Your Ref: 20-02083-OUT-4
Our Ref: AB/23933

HEMPTON ROAD, DEDDINGTON

We are in receipt of the Lead Local Flood Authority (LLFA) response to the above application and dated 25th March 2021. Taking the comments raised by the LLFA I have outlined a response to each below.

Infiltration Basin Details:
 Design based on Impermeable Area of 0.676ha (as measured from architects layout with an additional 10% allowance for urban creep)

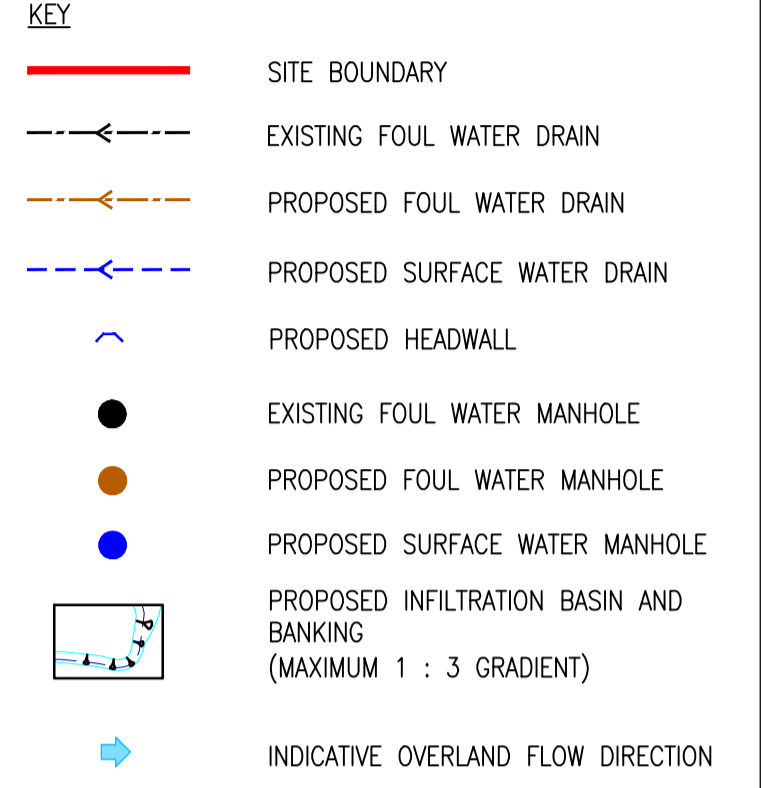
Phase 1, under the application ref: 18/02147/OUT - 3, which was conditioned, states the total area of going into the Infiltration Basin as 0.74ha (Drawing Number 23933_01_230_01 Rev C). However, in the new strategy submitted, the area shown going into the infiltration basin is 0.676ha (Drawing Number 23933_01_230_03 Rev A) with a larger boundary. This needs to be clarified.

The drainage drawing must indicate clearly the impermeable areas being drained into the infiltration basin.

According to your proposal, it can be seen that the scheme is split into two phases, A and B. However, if the overall scheme is to use this one infiltration basin as the sole drainage system for both phases (1 & 2), the calculations and strategy must reflect this. The drainage layout must show the whole system for both phases, 1 and 2 as it's draining to one point, the infiltration basin. Therefore, when carrying out calculations for infiltration basin, the whole impermeable area in ha, for Phase 1 & Phase 2 must be taken into account.

Furthermore, a larger infiltration basin might need to be provided in order to infiltrate run off from both phases, 1 and 2. This must be assessed by the applicant.

Please correct the "Attenuation Basin" label on drawing "23933_01_230_01 Rev C". Currently it shows the basin labelled as "Attenuation basin" but it should be labelled as "Infiltration basin" as the proposal is infiltration.

The observation made by the LLFA is correct. However following receipt of more detailed information on Phase 1 from the now developer of this site and their consultants Experdite, it was observed the impermeable area for Phase 1 has reduced and so the overall impermeable area for both phases is now identified as 0.676ha.

On that basis the correct impermeable area, based on all available information, is stated on drawing 23933_01_230_03 Rev B which is contained in the submitted M-EC Drainage Statement (Ref. 23933-01-TN-02 Rev C).

The impermeable areas are noted on drawing 23933_01_230_03 Rev B.

Drawing 23933_01_230_03 Rev B clearly shows how the site is drained and the submitted Drainage Statement contains detailed network calculations which show how the whole site works taking into account both Phases 1 and 2 impermeable areas.

The calculations clearly show that the infiltration basin doesn't need to be made any bigger.

Drawing 23933_01_230_03 Rev B states the basin the basin is an 'Infiltration Basin' not an attenuation basin so no changes are required.
